2022/1036

Change of use of storage unit serving a shop to a dwellinghouse

134 Rotherham Road, Smithies, Barnsley, S71 1XA

Proposed Site Plan

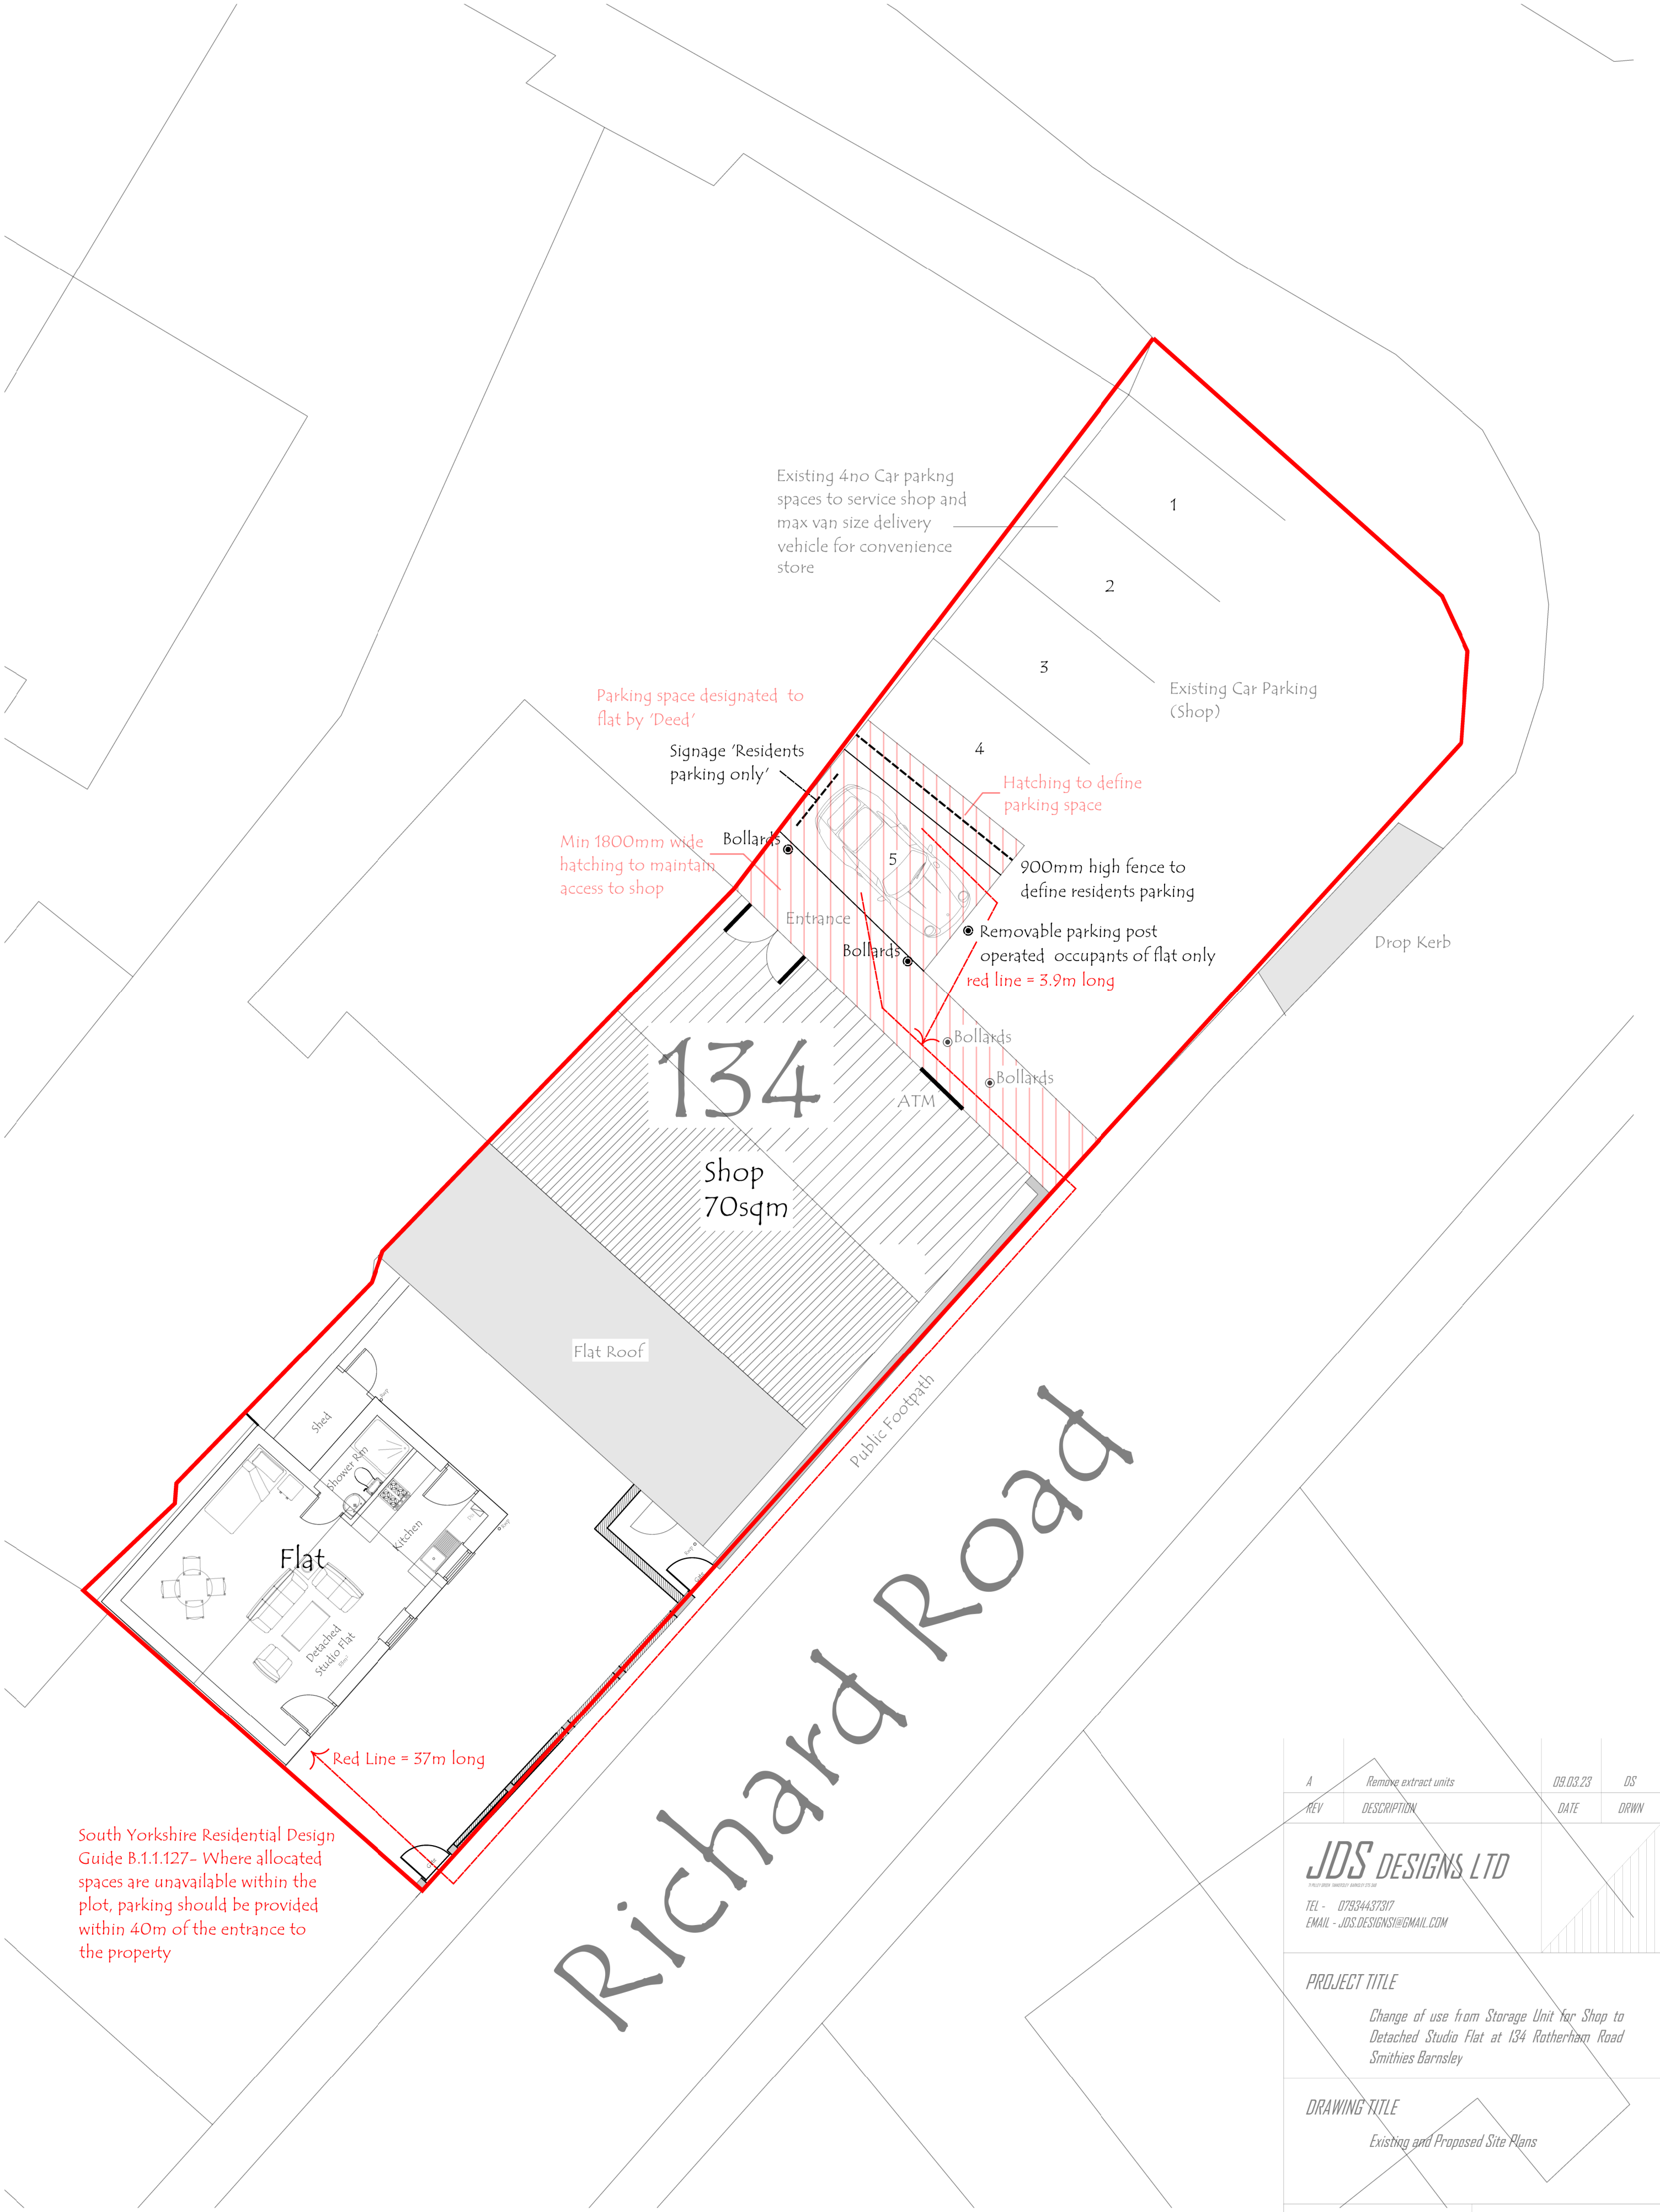
However, it should be stressed that this expectation is a minimum requirement and consideration must also be given as to whether the proposed amenity space is of sufficient quality and is indeed private. In this case, the proposed amenity space is located to the front and side of the building, with an amended plan showing that the existing front boundary wall will be removed and replaced by a wall/fence with a maximum height of

1.2m. The amenity space will be in clear view from the adjacent road (Richard Road) as well as from neighbouring properties, with little obstruction given that the boundary wall will be removed and replaced by a mid-height wall/fence. The amenity space is therefore not private, is marginally above the minimum standards expected and the newly formed area to the side (due to part of the building being removed) will be enclosed by the building and the retail unit to either side. The amenity area will therefore be significantly enclosed and overshadowed by a mixture of the proposed boundary wall and the convenience store and the building itself and the end result would be poor quality amenity space. Further to this, the proposed dwelling shows a minimum number of openings, solely located on the frontage which face onto a small forecourt area, a boundary wall, and the road. There will be very little outlook offered from the windows on the property which would accentuate the issues raised in terms of lack of adequate amenity space and the quality/standard of the living conditions offered by the unit is considered to be substandard and not in line with Local Planning Policies.

The proposed development seeks to include a parking space which is shown within the red line boundary of the wider site which includes the existing convenience store. This is located to the North of the store directly in front of the main access door for the shop in a forecourt area. This creates an arrangement in which future residents of the proposed unit would be required to leave the red line boundary and walk on the highway to the parking space which is located in a shared car park. The distance from the entrance door of the proposed dwelling to the parking space (door-to-door) is 34m. Highways initially expressed concern with this arrangement given the remote nature of the parking space and lack of information in regard to the parking layout for the store alongside the future resident's parking. Upon receipt of this information, concerns were raised by highways who reiterated concern in regard to the remote location of the parking and the likelihood of indiscriminate parking on the highway rather than the use of the proposed parking space.

The agent has provided details as to how the parking space would be managed by showing details on the amended plan such as a 900mm fence to the side of the parking area, hatching on the ground and signage indicating that the space is for residents only. However, these measures would rely on a private arrangement between the shop owner and the future resident which is not controllable or enforceable by the Council. The removal of this agreement is a further future concern which would increase the likelihood of indiscriminate parking on the highway, to the detriment of the safety of other road users. As mentioned above, the area is characterised by street parking (not entirely) but there is a row of double yellow lines immediately adjacent to the site. Regular indiscriminate parking in this area would therefore be to the detriment of the local highway network, which is contrary to Local Plan Policy T4 and the Council's Parking SPD and is unacceptable in terms of the proposed parking arrangement and the detrimental impact it will have on the nearby highways network.

The proposed outbuilding is relatively unchanged from the existing arrangement with the exception of the reduction in its size/length by 1.35m and the replacement and repositioning of the windows on the front elevation. There are other minor changes to the wider site including the front boundary wall and gate being removed to make way for a replacement boundary wall with fence toppers, as well as a new pedestrian gate. The replacement wall is at a height of 1.2m at the highest and is considered an improvement in terms of design as it removes the existing large (c.1.5m) front boundary wall, and the proposed wall is similar to the surrounding street scene.

Proposed Ground Floor Plan

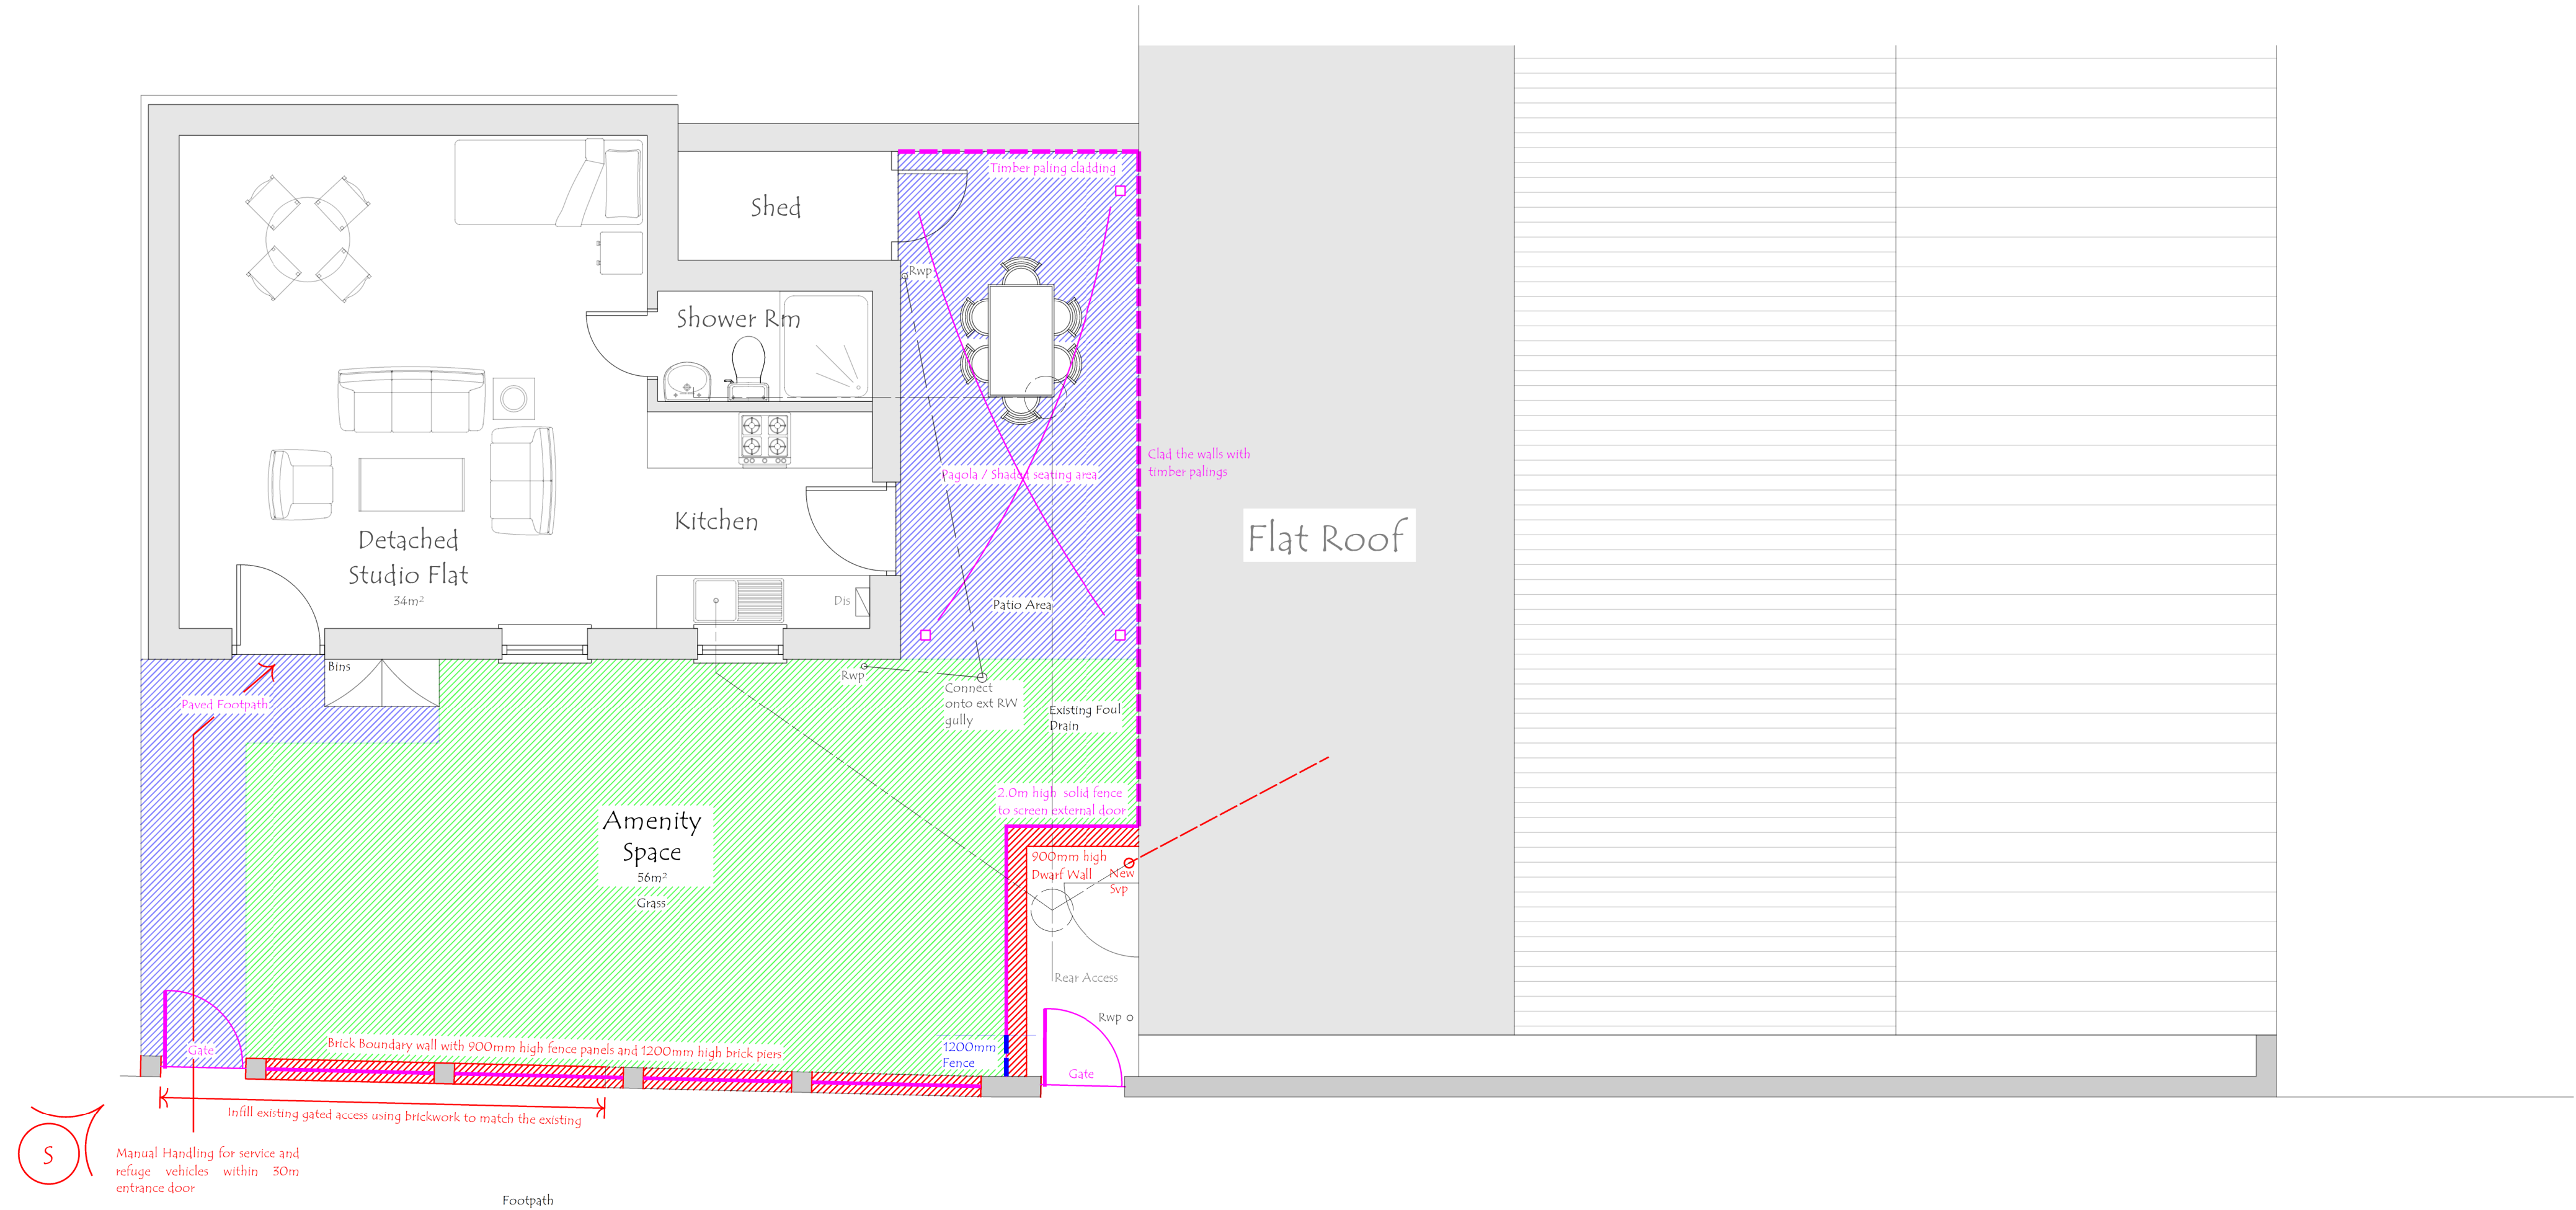
The proposed development has been amended numerous times with the final proposed plan showing a studio flat with a single bed, living/dining area and kitchen and a separate shower room. Part of the existing building is also to be removed to increase the amenity space within the proposed garden area. The internal size of the studio flat is 34sqm with the shower room measuring 2.75m. This meets the criteria within the SYRDG which requires a minimum of 33sqm for studios flats. The building also contains an attached shed to the rear measuring 2.7sqm which can be used for storage.

The Council has an adopted SPD for Design of Housing Development which states that new dwellings and flats with 2 or less bedrooms should have a minimum of 50sqm of private amenity space. The amended proposed plans show that there will be 56sqm of amenity space within the site, which exceeds the 50sqm expected in the SPD. This amenity area is partially due to the fact that part of the building will be removed to form additional space within the site.
